January 22, 2018

RE: **Heritage Marketplace Tract A2 (Burger King)**
7900 Ladera Dr NW
Grading and Drainage Plan
Engineer's Stamp Date 12/27/17 (File: H09D024A)

RE: **Heritage Marketplace Tract A2 (Burger King)**
7900 Ladera Dr NW
Grading and Drainage Plan
Engineer's Stamp Date 12/19/17 (File: H09D024A)

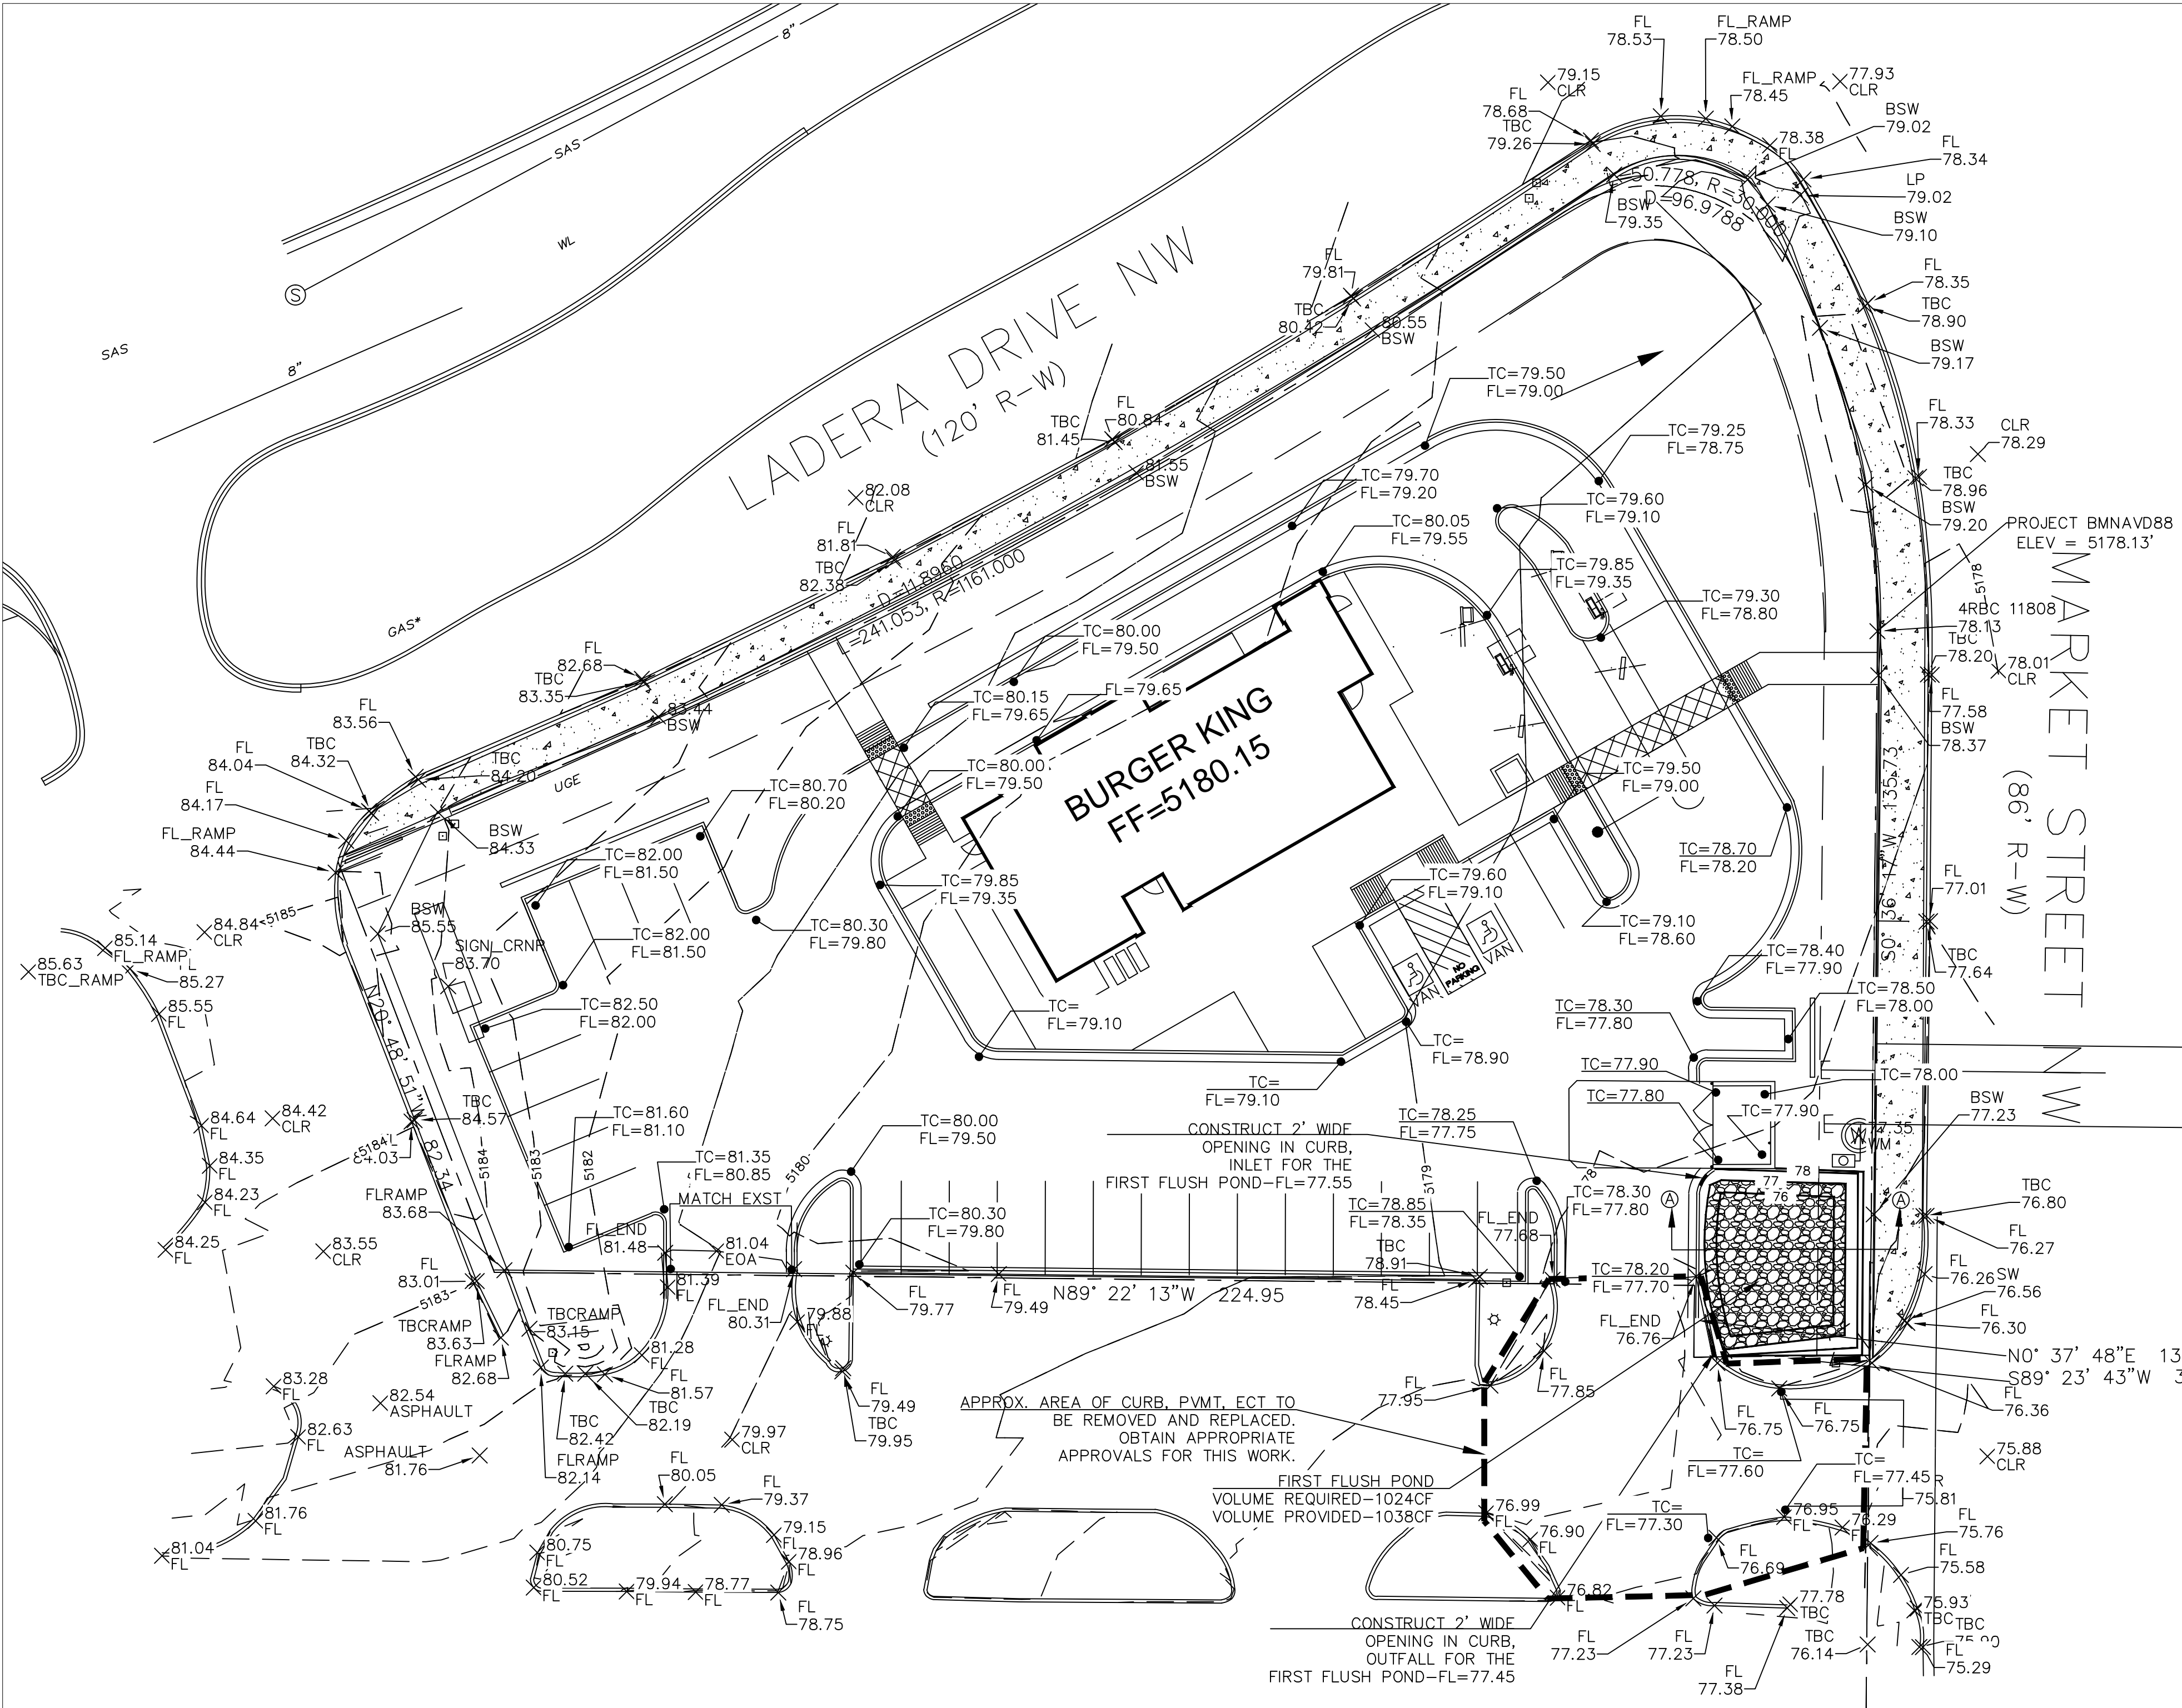
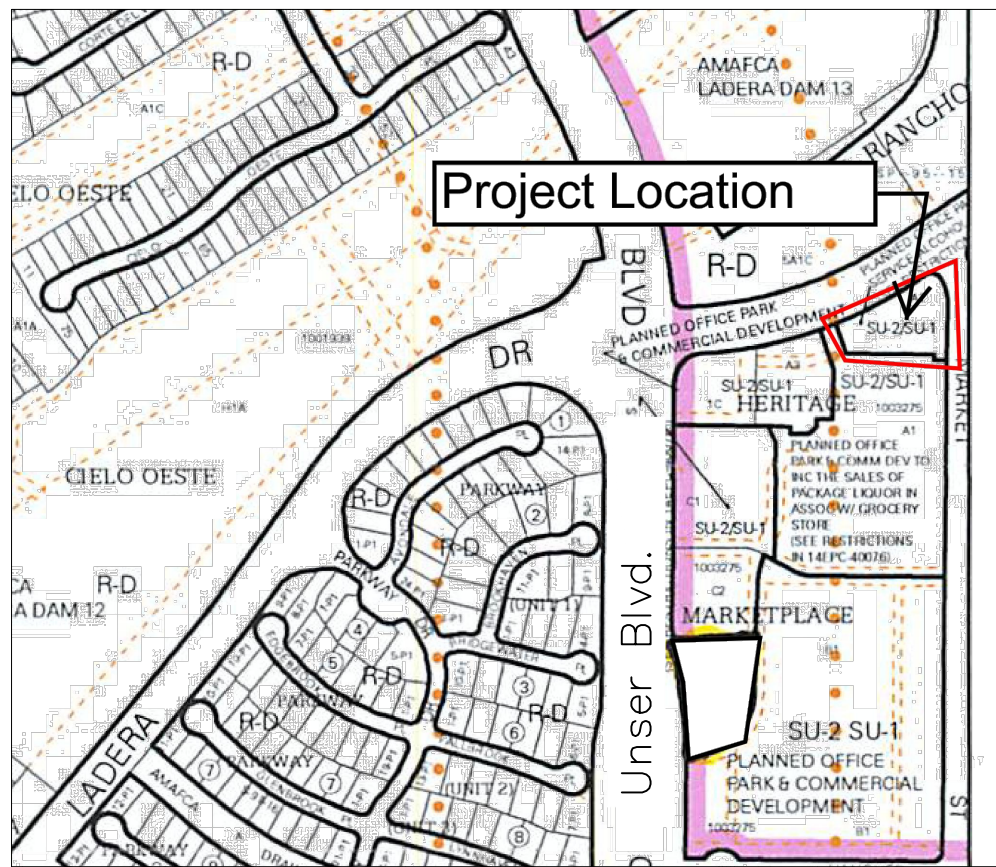
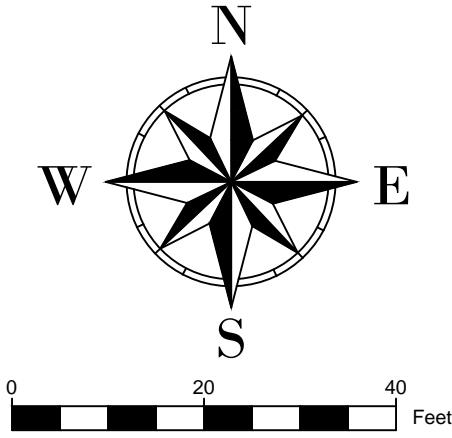
1. The Grading and Drainage Plan will need to be clearly labeled as "Conceptual, not for construction" for inclusion in the Site Plan.
2. Include a narrative describing how this plan of development is in compliance with the approved Heritage Marketplace Drainage Report (H09D024).
3. The dumpster area should be contained, plumbed through a grease trap, and into the sanitary sewer. Include the utility plan if this information is located there. You may also want to raise the dumpster pad elevation to keep storm water from entering the dumpster area.
4. Please provide written permission from the adjoining property (Walmart) for work on their property.

5. A detailed grading and drainage plan, with the "conceptual" markings removed will be required for Building Permit.
6. It is unclear that storm water will be forced into the pond at the curb cut. Please include a clearly defined waterblock at the SE property line/drive entrance that will force flows into the pond instead of allowing them into the Walmart parking lot.

1. I incorporated these changes into the drainage plan. (for site plan approval)
2. The drainage narrative note no. 2 has been expanded on to help clarify how this site conforms with the overall master drainage plan for this area.
3. I incorporated these changes into the drainage plan.
4. This is presently being worked on.
5. This will be done when after the "conceptual drainage plan" has been approved.
6. I incorporated these changes into the drainage plan.
7. This item will need to be provided with the 'drainage plan for building permit'.
8. Thank you for the information.
9. The Private Facility Drainage Covenant will be provided for C.O.
10. Thank you for the information.
